Planning - Case Comments

Project Number: PR-2019-002380

Project Name: 10000 Central Ave SW

Request: Site Plan Administrative DFT

SHEET NO:
L1.2
4 OF 14

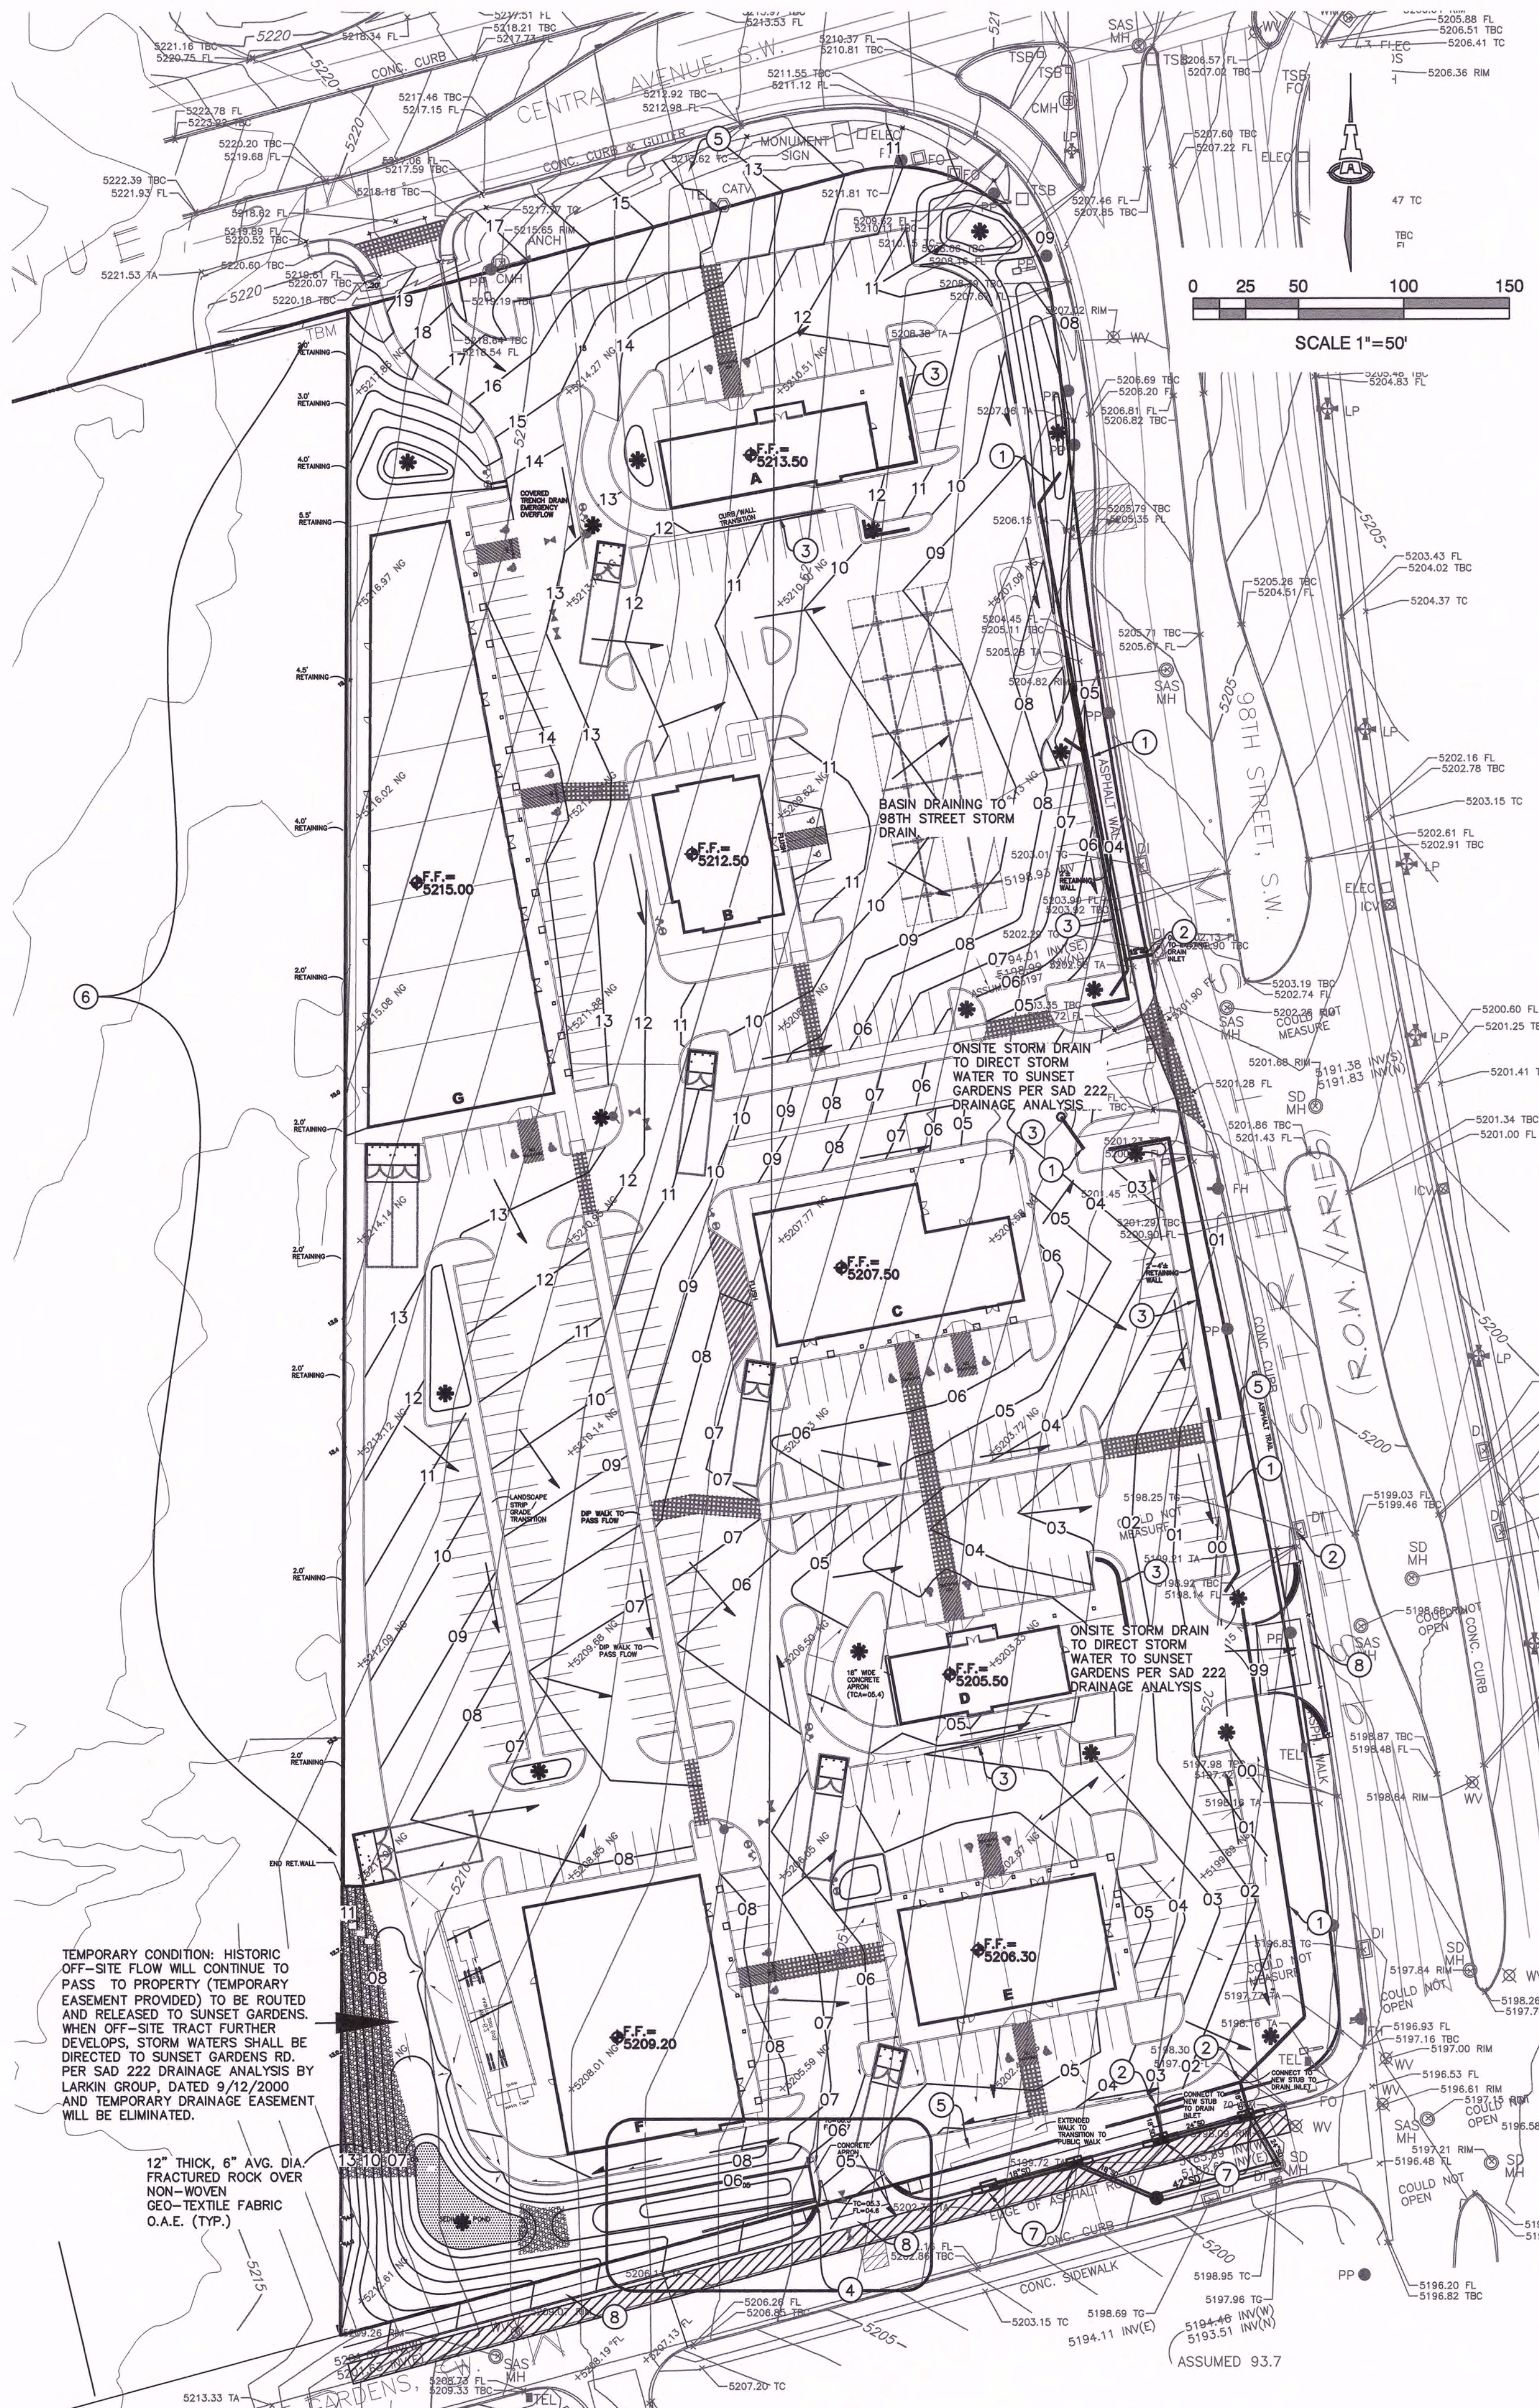
- Please replace the note below from Sheet No. L1.2 with the information from 5-6(C)(5)(e) as it is in conflict with the IDO.

- 5-6(C)(5)(e) Organic mulch is required as ground cover under trees, not including street trees, within a 5-foot radius around the tree trunk, but not directly against the trunk. In these areas, weed barrier fabric is prohibited. (See figure below.)

See revised Sheet L1.2

See revised detail Sheet L1.2

SHEET NO:
A2.7
14 OF 14

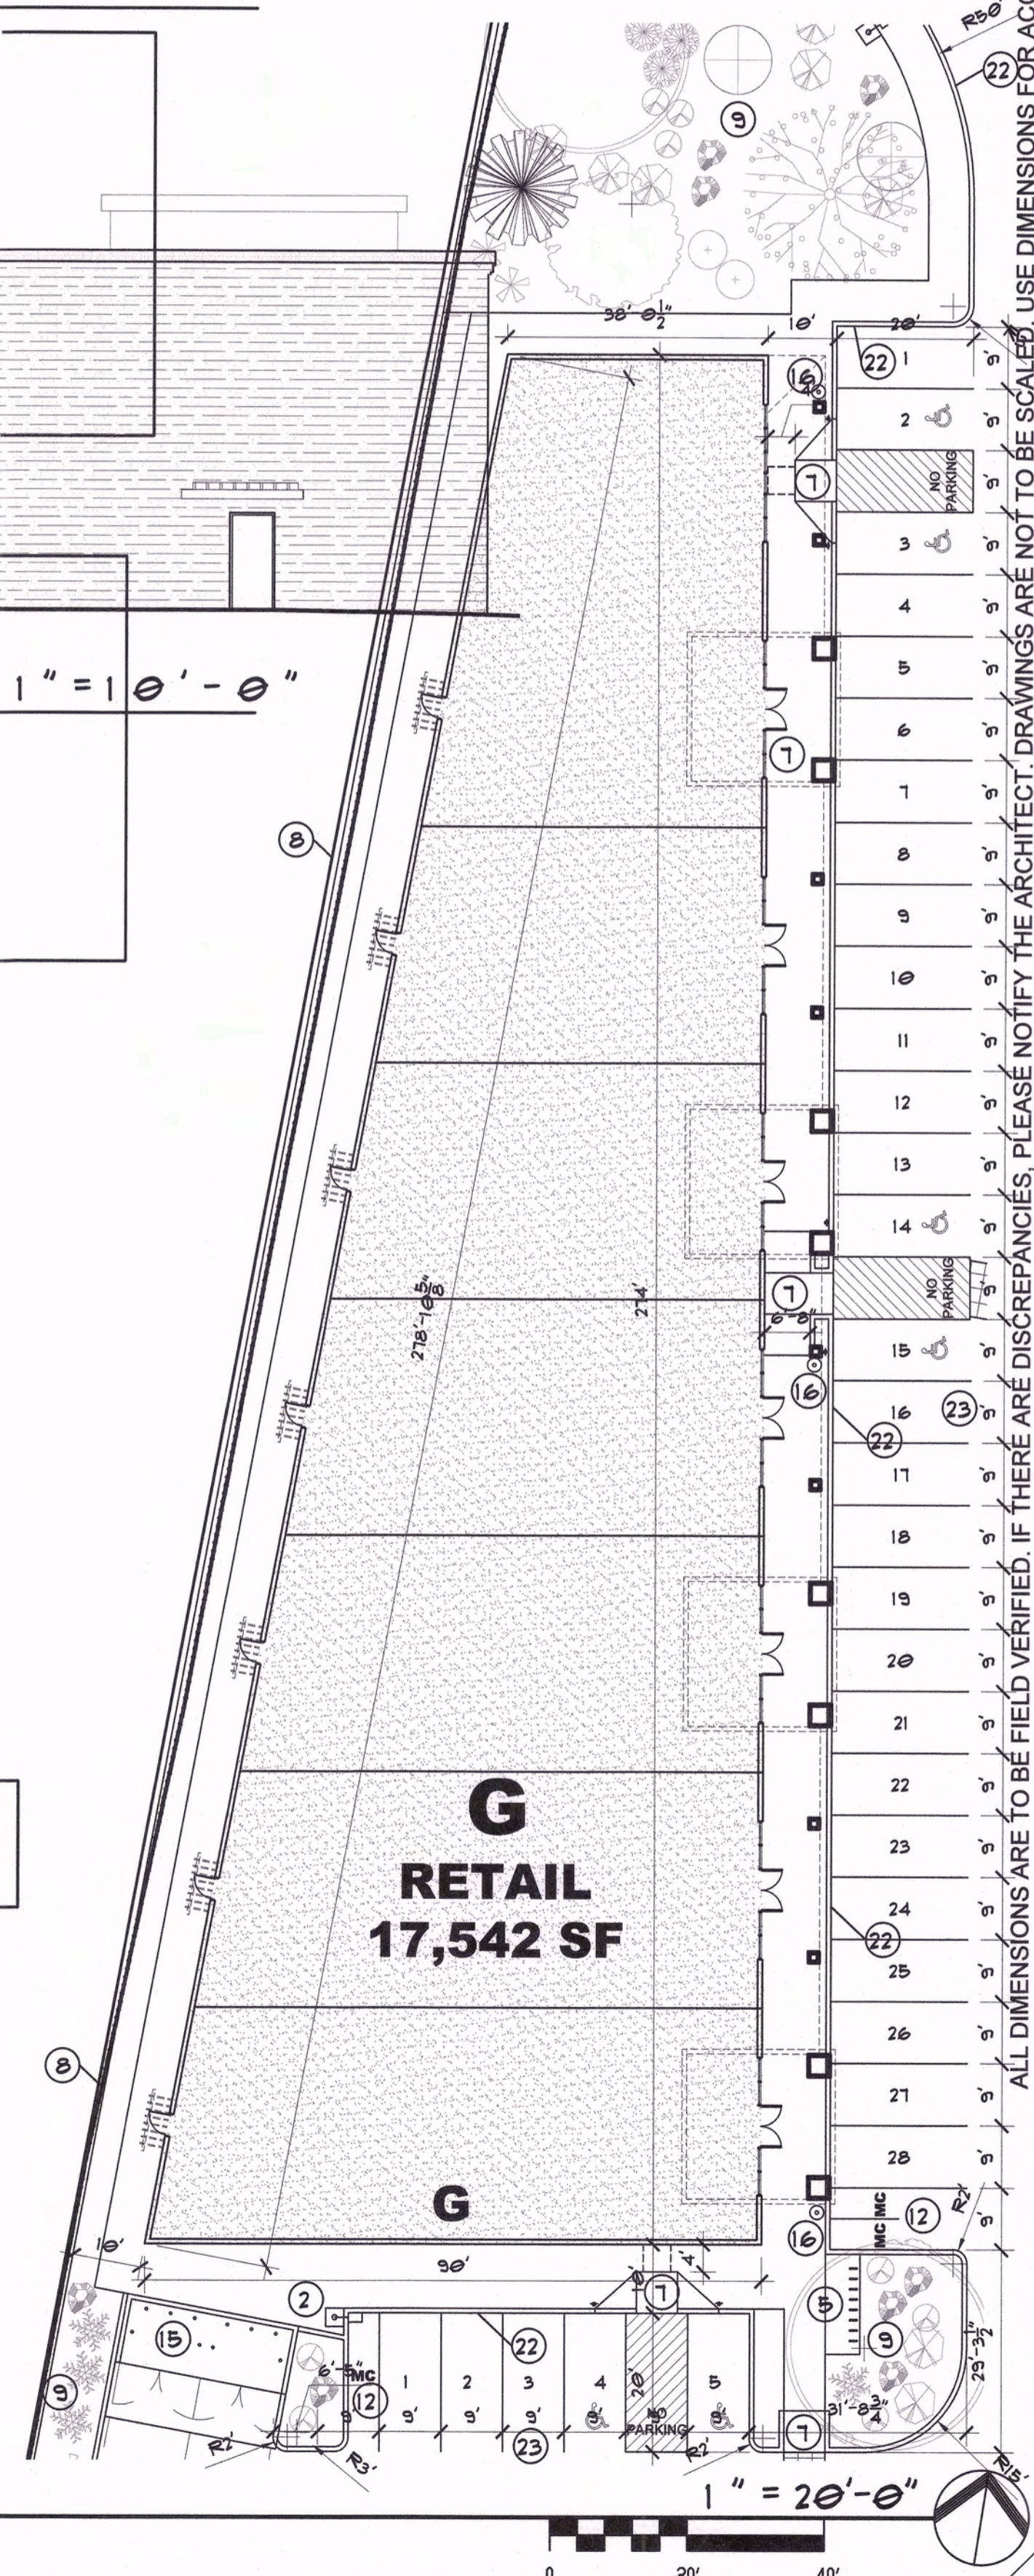
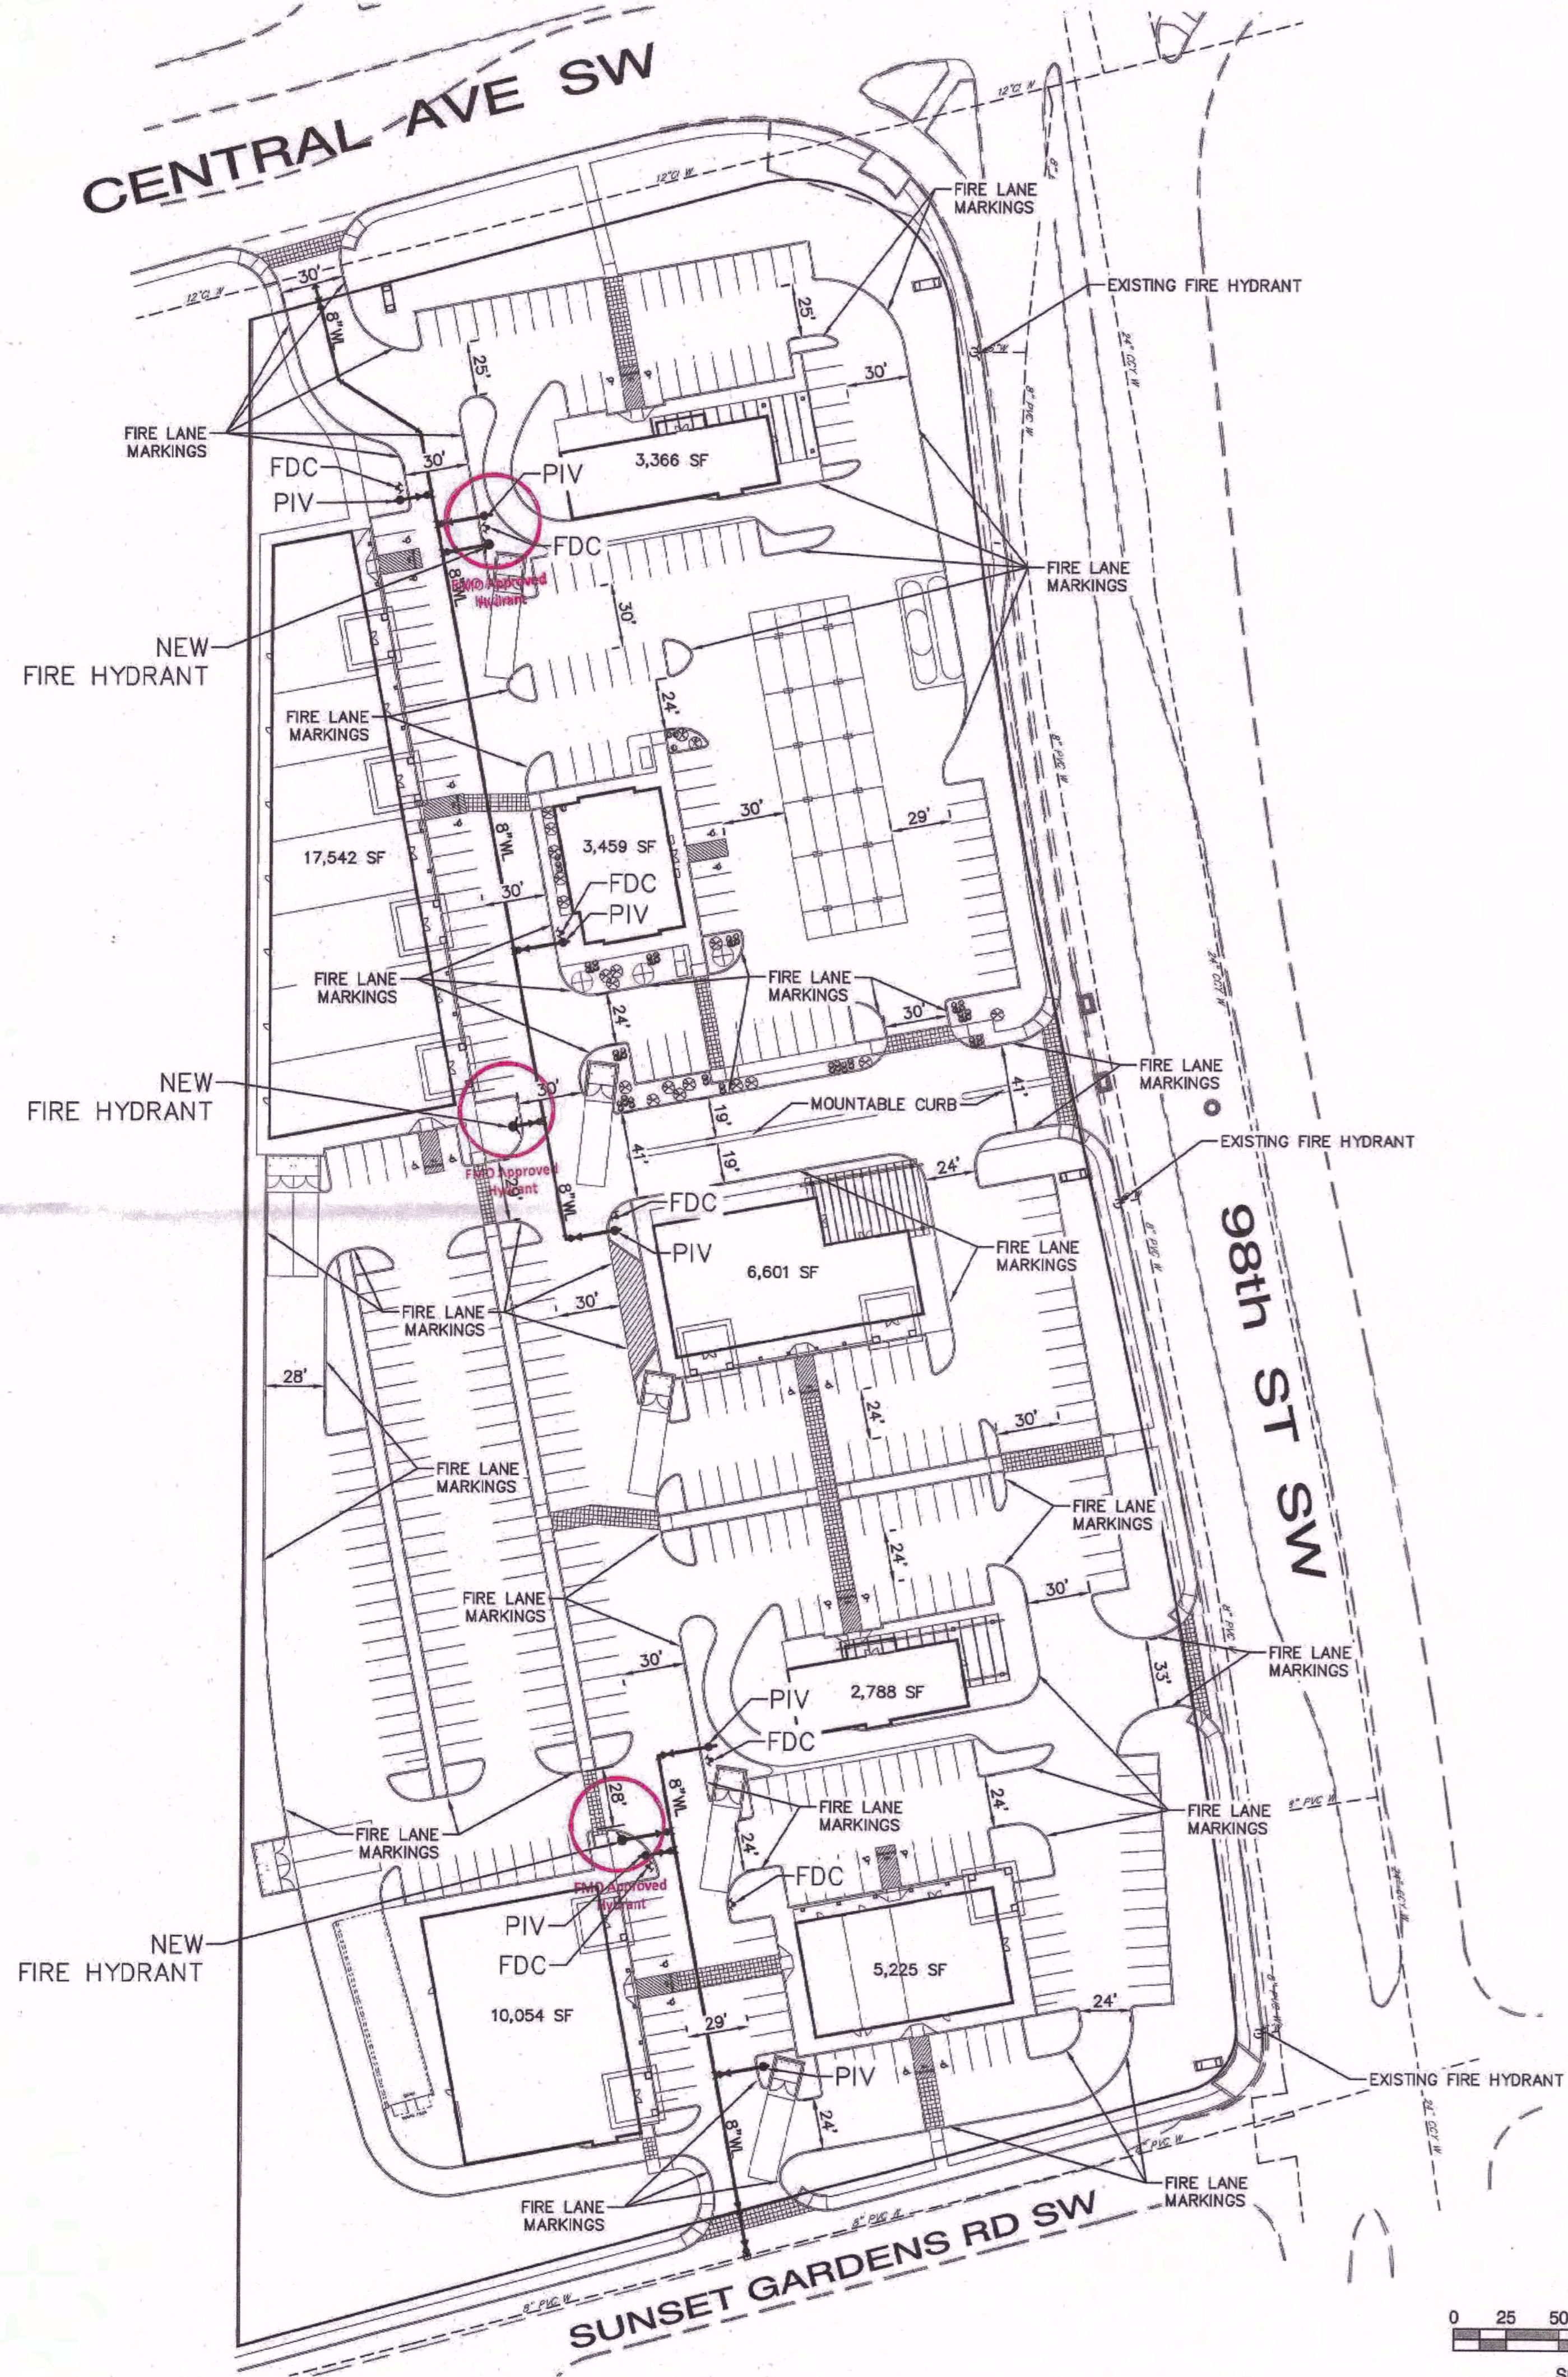
Parking requirement = 3.5 spaces per 1,000 sq ft GFA rounding down to the nearest whole number, would be **26 spaces** for F1 and **28 spaces** for F2. [See revised calcs Sheet A1.2 and A2.7 for screening](#)
